Objection

Re Planning Application Y/70/20/OUT

EXISTING SITE PLAN/ANALYSIS

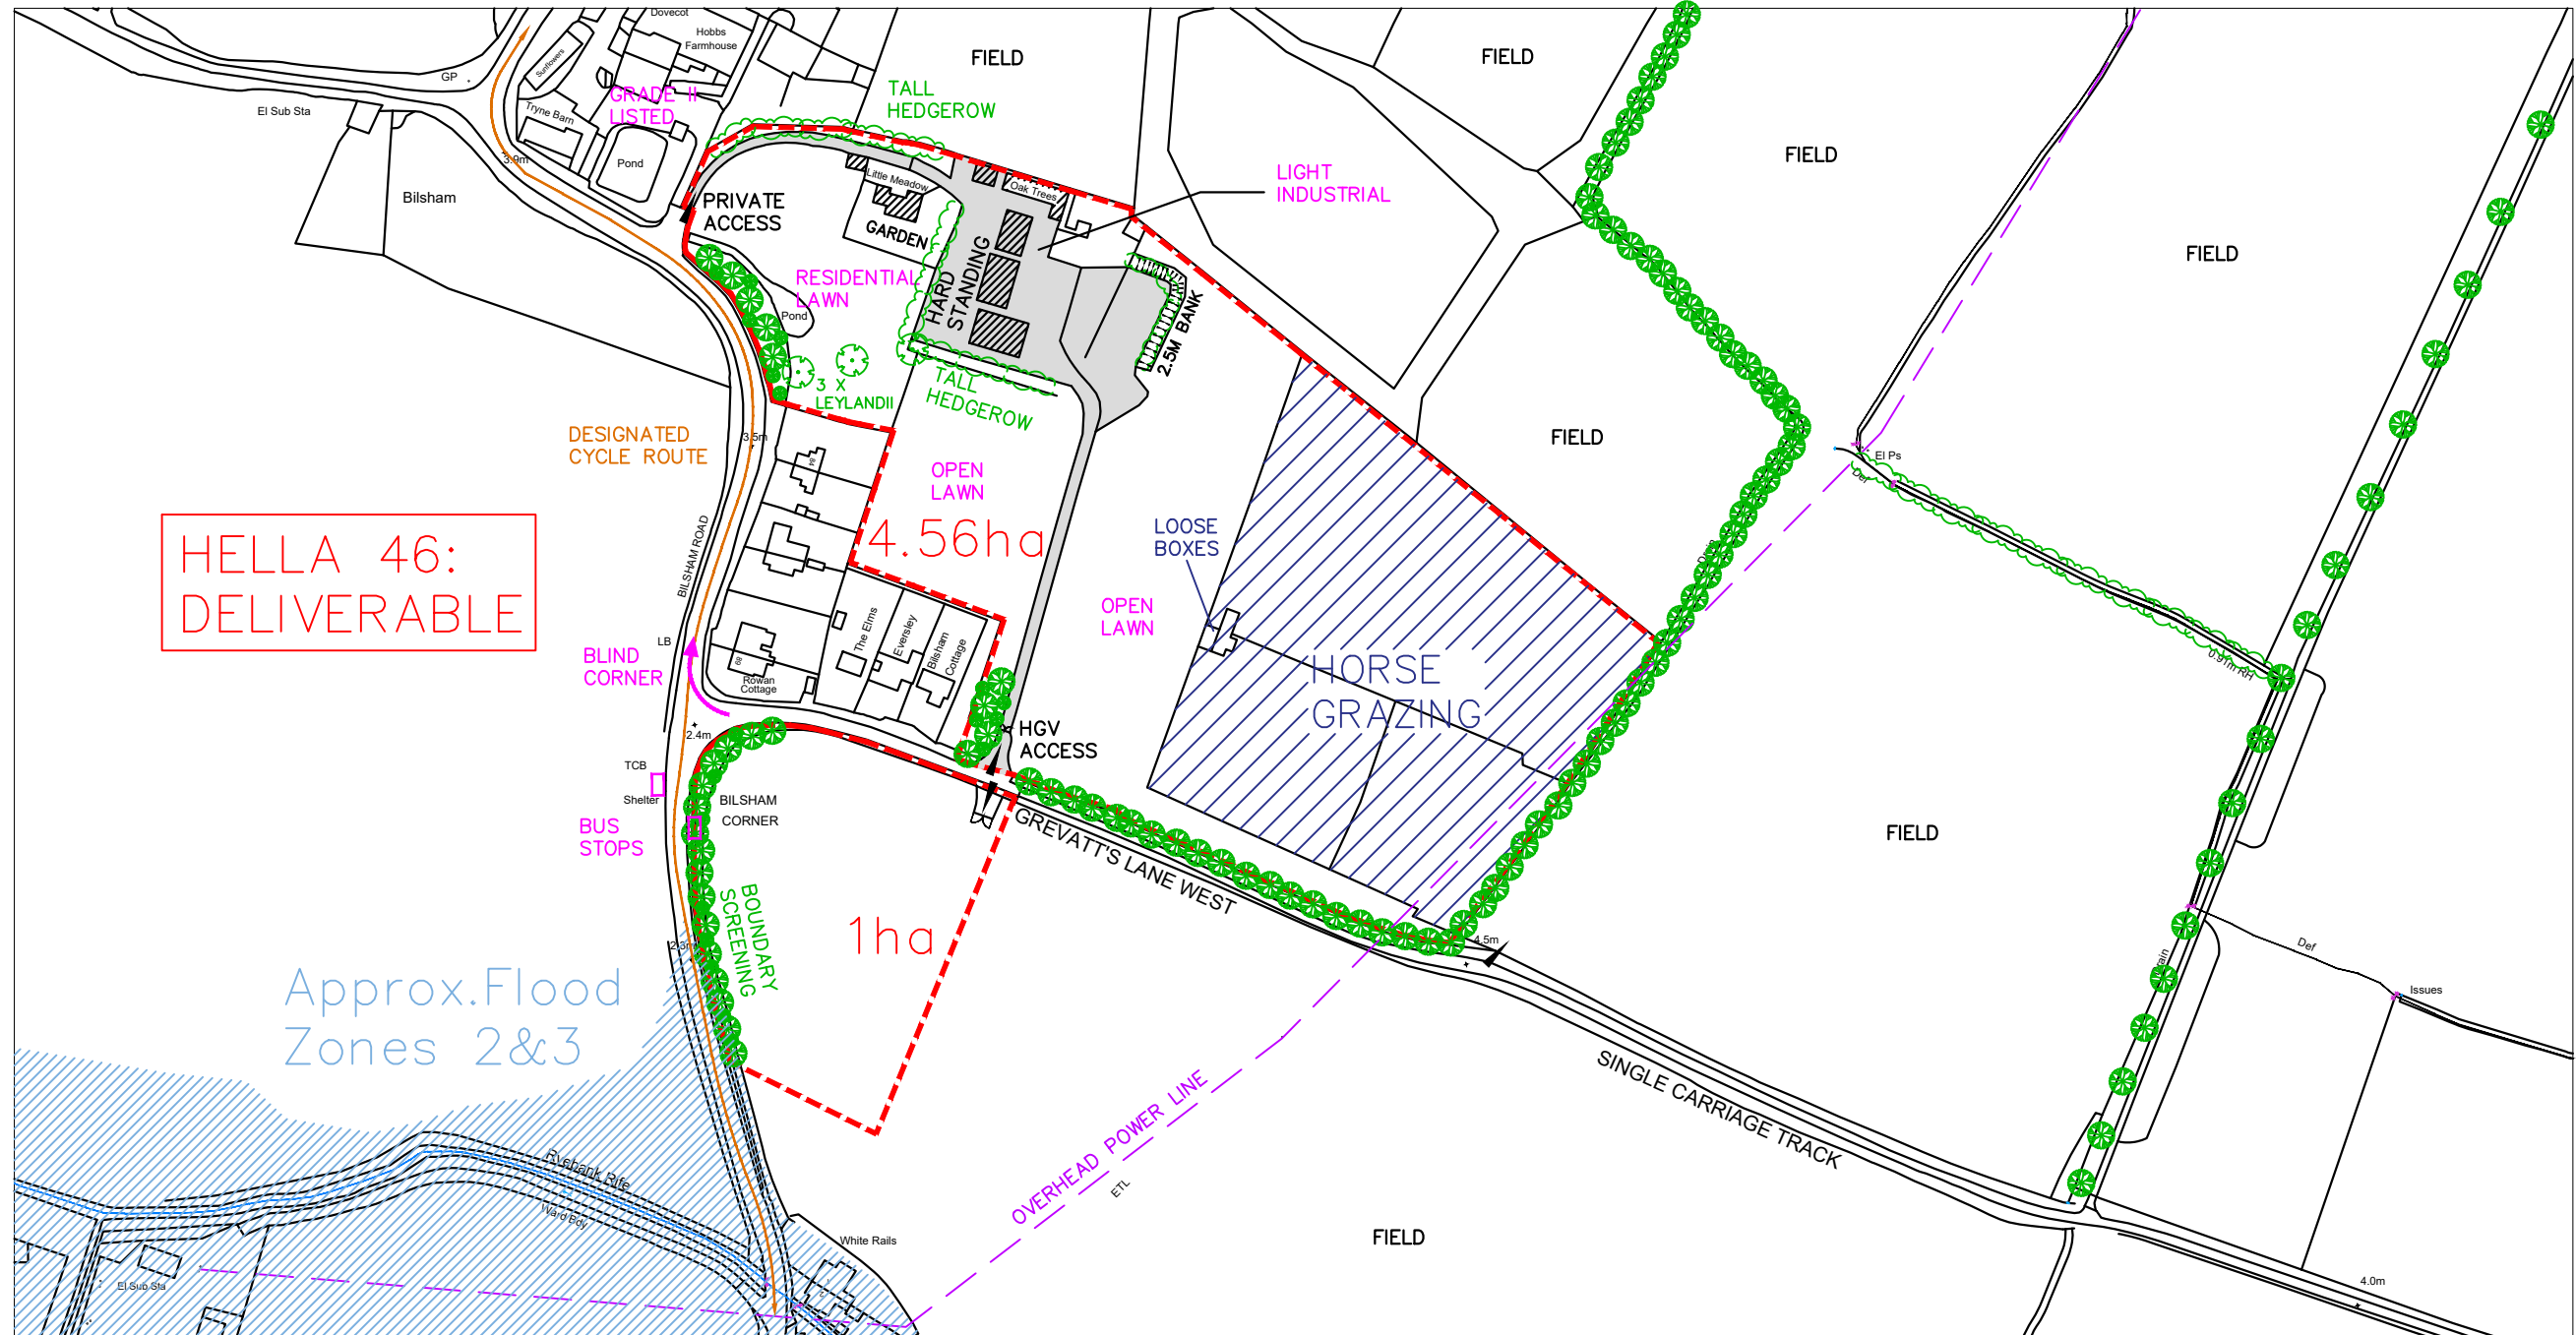
The submitted Existing & Proposed Site Plans provided by Critchley Architecture and Design appear to be inaccurate in regards to their annotation of scale. Both drawings include 2 no. separate linear scale bars with no reference to the independent scale of each. Both of these however do not align with the stated scale of 1:2500:A3 and therefore no accurate scale bar is provided to represent 1:2500@A3. Based upon a scale of 1@2500@A3 the existing portion of the site labelled as containing ‘4.56 hectares’ would represent a revised figure of 5.1 hectares ie. a variation of circa 12%. It is therefore unclear how these drawings were validated by Arun District Council ahead of the Public consultation period.

The outline of the existing ‘Light Industrial Use’ within the Existing Site Plan is inaccurate and represents a lesser size than that currently occupied by this use. The hatched zone suggests an eastern boundary formed by hedge rows and ‘2.5m’ high embankment determines the eastern edge of the existing Light Industrial zone where in reality this has since been removed and yard expanded to the east. The figure stated as 4000m² within Section 6 of the Application form is therefore inaccurate. It should also be noted that the hatch representing ‘Light Industrial’ use appears to include one of the primary dwellings within the site (Oak Trees), as well as any private amenity space and dedicated access associated with this residential property. It is therefore felt that the boundaries and annotation represented within the site plan does not accurately represent the existing site and should be revised to provide a true reflection of use classes. It is also assumed that the Case Officer has reviewed the permitted use classes that are stated as being present within the site to confirm that these have been assigned historically or applied for through previous application.

The Existing Site Plan does not represent an accurate reflection of the existing condition. It is noted that a number of static homes have been erected which include additional platforms (verandahs) serving as private amenity space/permanent accommodation within the boundary of the site. A number of additional structures serving the

Light Industrial use are also evident. These do not appear to have been included within the Existing Site Plan, nor do these structures appear to have been granted consent by Arun Planning Department. It is assumed therefore that based upon historical site photographs obtained by Arun Planning July 2013 (stated within the Case Officer's email dated 20th August) those structures deemed to be new will be identified and included within a revised 'Existing Site Plan' to ensure accuracy.

By carefully comparing aerial maps from two sources which are in the public domain (Bing and Google) clearly taken at different times it is very evident that the industrial site has over recent time been developed. For example a static home has been sited on the Northern Boundary.

FIGURE 2
Proposed new access

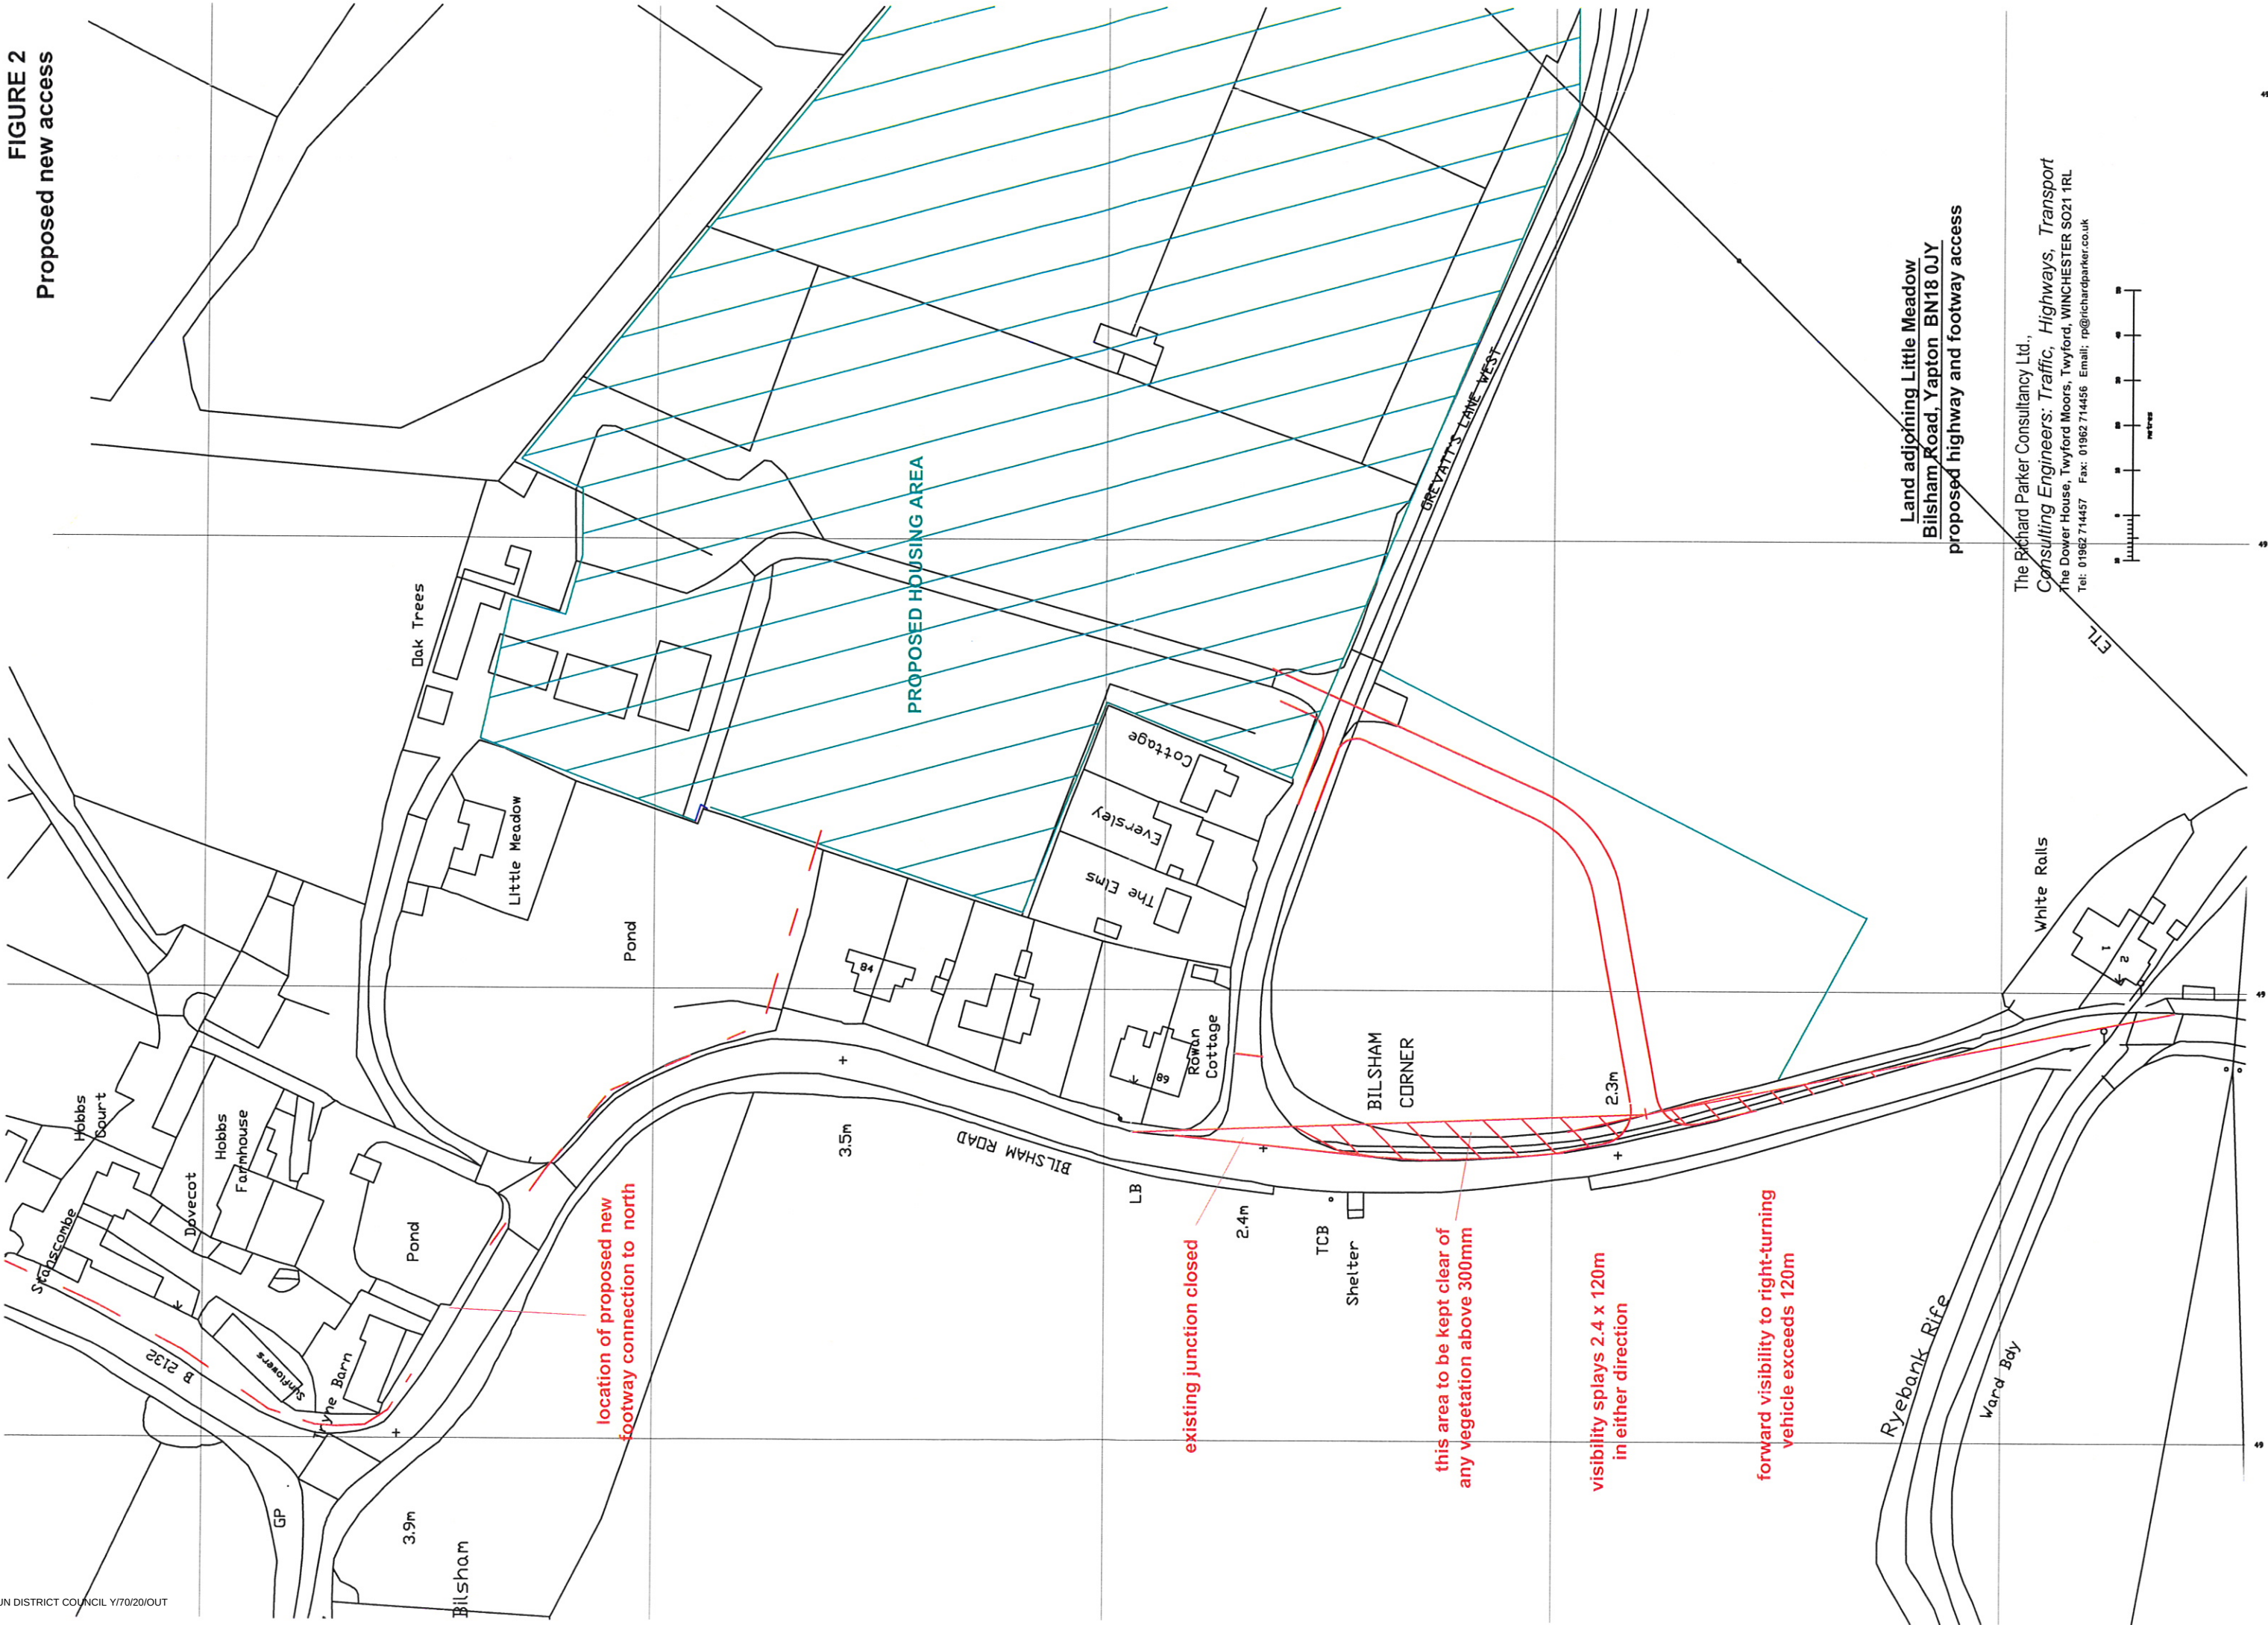
The adopted Highway plan does not appear to include the full site upon which this application is based.

The annotation and hatch specifying the extent of the "Proposed Housing Area" does not align with that of the main application submitted by the agent. This would suggest from the general arrangement and extent of hatching that the existing light industrial units are to be altered in class to 'C3' classification where as other materials submitted under this application propose that the light industrial buildings/site be increased in capacity. It therefore appears that the Transport & Highways Appraisal excludes the presence of industrial/commercial vehicles such as HGVs, arctic lorries, etc from its analysis of vehicle tracking as well as their access to and from existing congestion junction leading onto the B2233.

The New Access Figure 2 diagram does not provide a proposal beyond the junction at which this meets the existing Grevatts Lane West. This diagram should include additional detail in regards to potential widening of access road to serve the proposed increased capacity of the industrial zone (approx. 200% increase in capacity) including coordination of these access roads serving new village Hall, and new dwellings, including safe access to such areas as new village green and play park and public amenity spaces which will need to cross the route serving the increased capacity of industrial/commercial vehicles. The design of the new road also excludes the access this will need to provide to the Bilsham Corner plot which has been proposed to include 18 dwellings.

There appears to be no confirmation that emergency vehicles will be able to fully access all the proposed new road works.

The New Access Figure 2 diagram has not been coordinated with the applicant's proposed site plan in which an additional network of road and a mini roundabout are proposed. It would therefore appear that this diagram provides an independent analysis of providing an alternative access route to Grevatts Lane only. This document

therefore does not take into consideration how industrial/commercial vehicles will affect the stress testing and tracking requirements to navigate safely within high density play areas and residential environment. It is also evident that the provision of secondary access roads to serve the proposed residential plots has not been coordinated or considered as part of this analysis.

The New Access Figure 2 identifies a large strip along the Eastern side of Bilsham Road, south of the new road junction, which has been identified as requiring continual maintenance to ensure the vegetation is retained at a height of less than 300mm to ensure good visual access at the new junction. It should be noted that this will require the removal of hedgerows and a number of trees and goes directly against the advice received from CDC Ecology who have stated clearly that these hedgerows are to be “retained and enhanced” to support the existing population of bats. Further to the above, it is noted that the Proposed Site Plan includes extensive ‘boundary screening’ along the eastern verge which appears to contradict the advice of the Transport & Highways Appraisal which confirms that this zone would need to be maintained at a height of less than 300mm to ensure safe visual access as part of the new access road junction.
